**WEST SUSSEX COUNTY COUNCIL
PLANNING SERVICES CONSULTATION**

SUBJECT: A/176/17/PL- 2 No. dwellings. This application affects a Public Right of Way.

Land between Badgers & Ashurst Ham, Manor Way, Angmering

Site Plan (1:200)

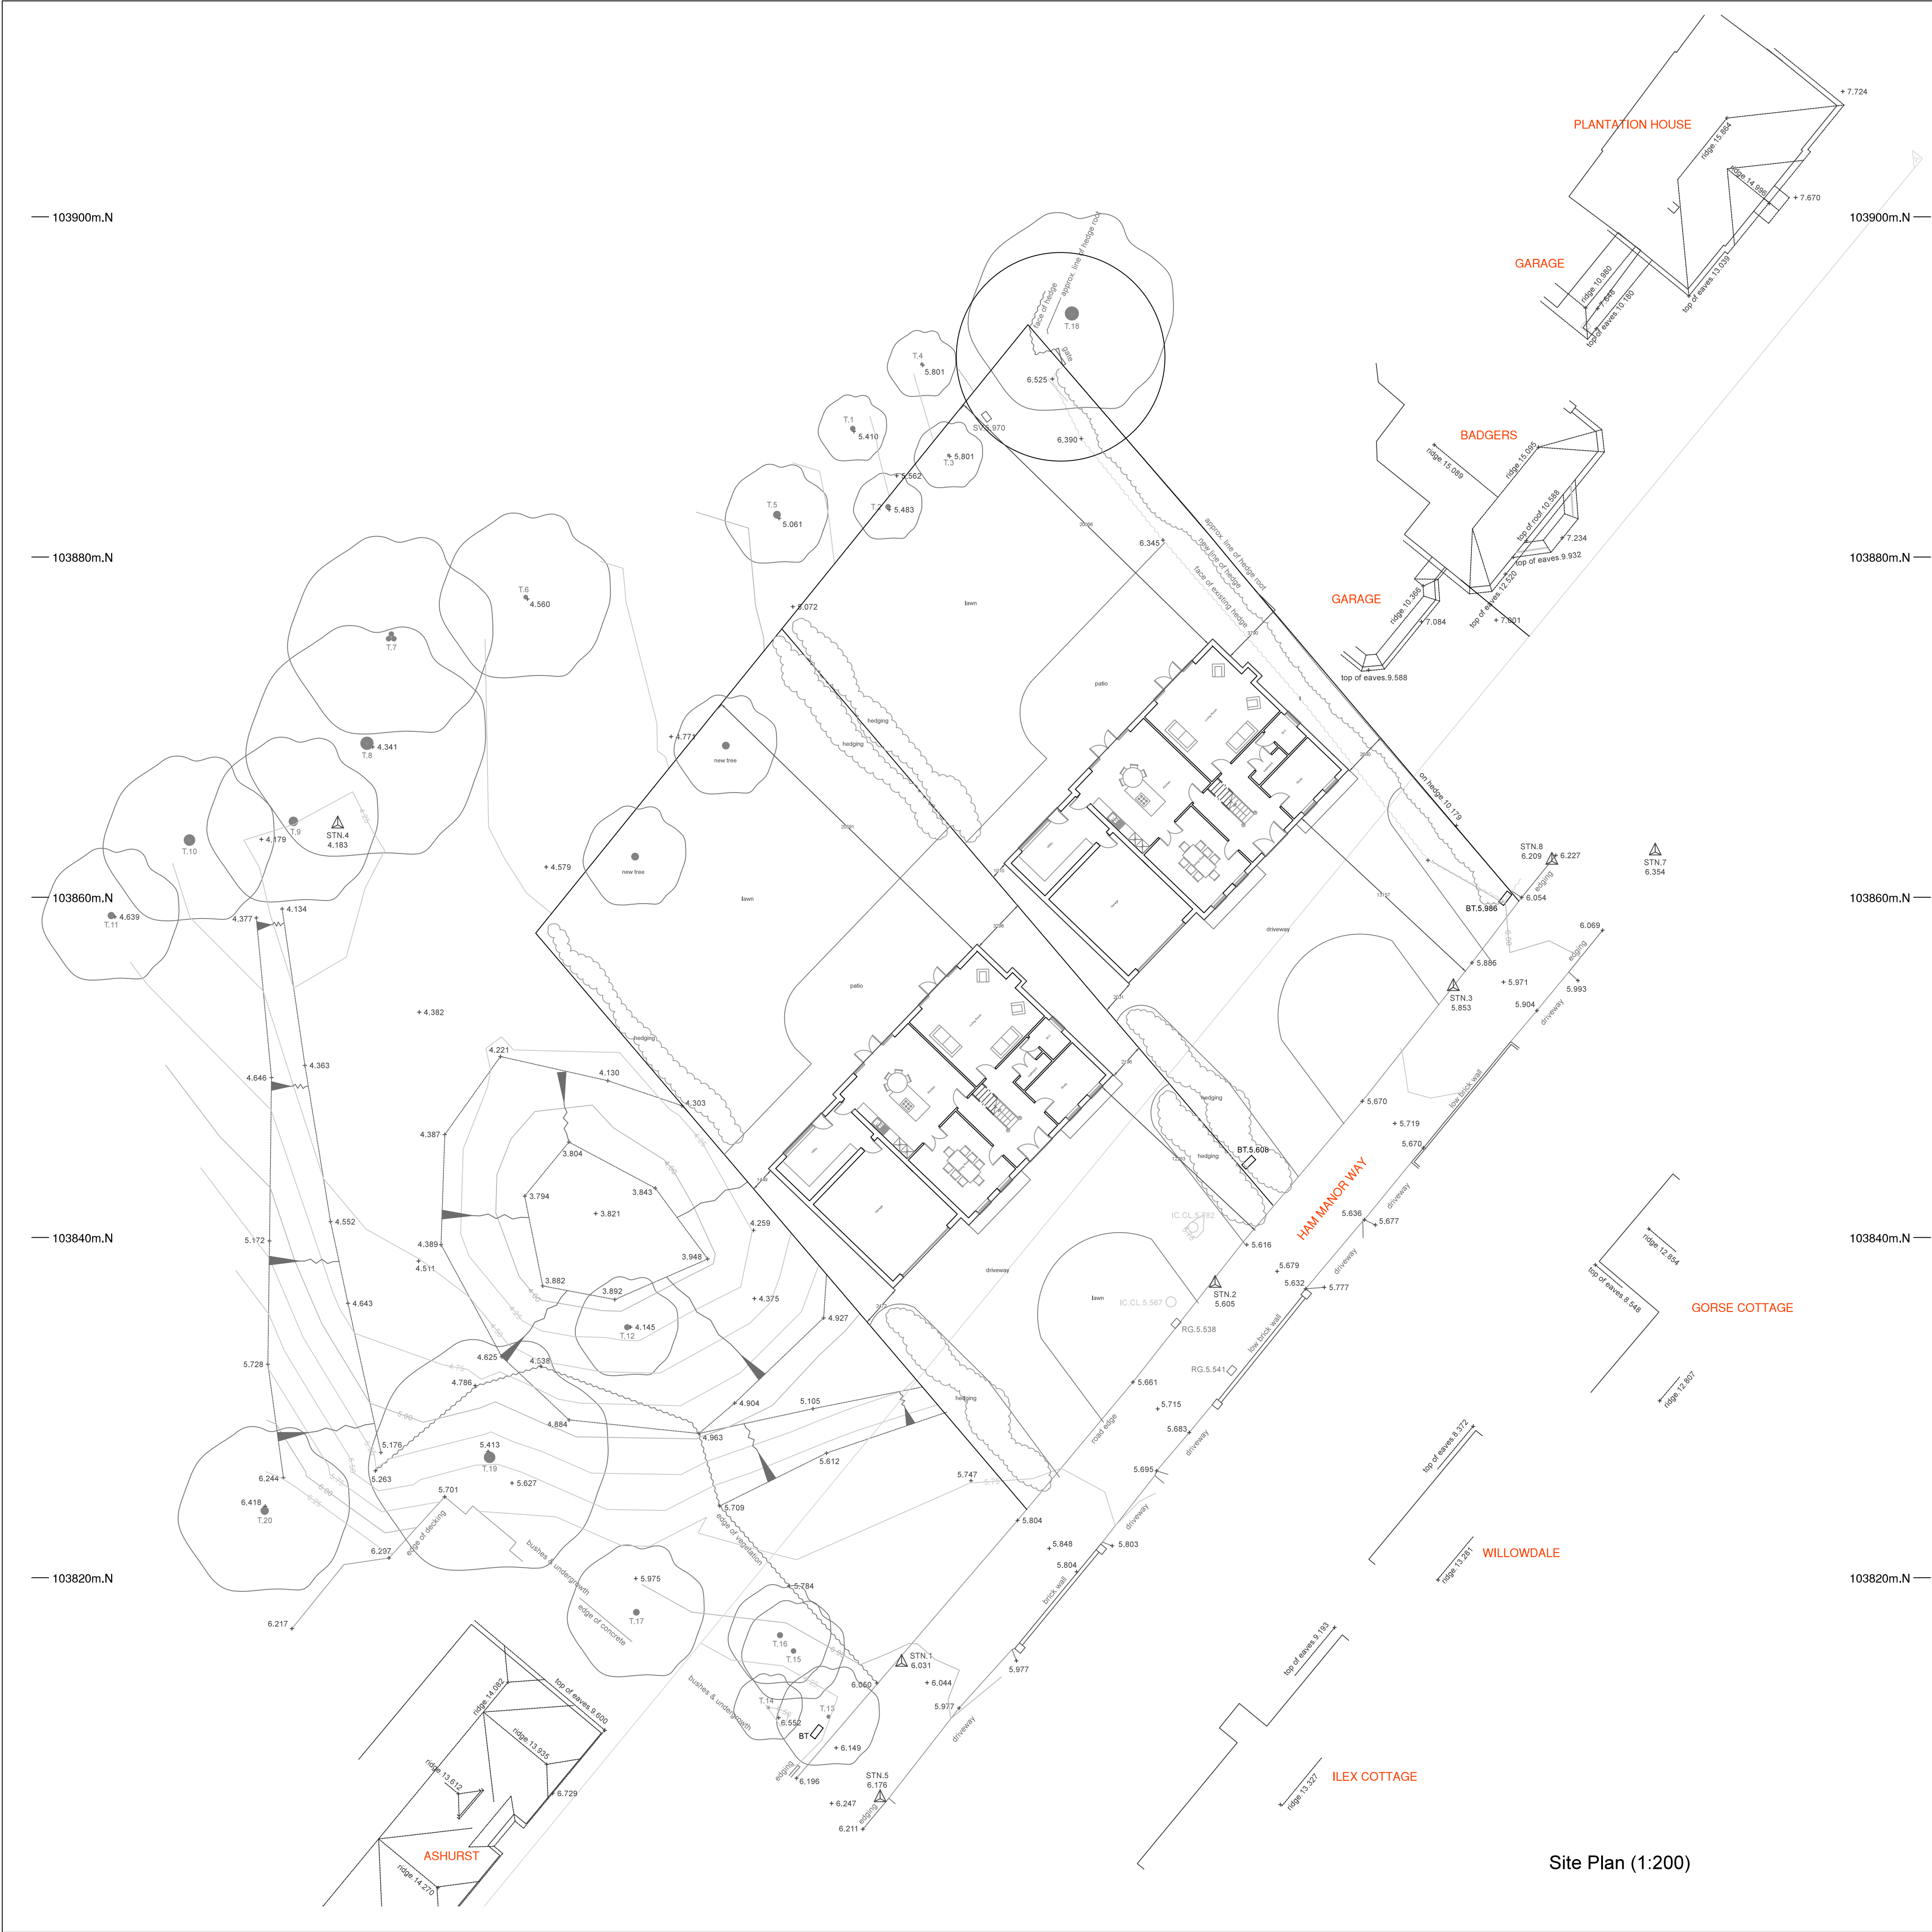
Ample parking and turning has been provided, including a double garage for each dwelling and 4 off road parking spaces. The double garages are advised to meet 6m x 6m in order to accommodate for cycle parking, there would appear sufficient space within the site to allow for this.

If the LPA are minded to approve this proposal a condition securing vehicular parking and cycle parking should be included.
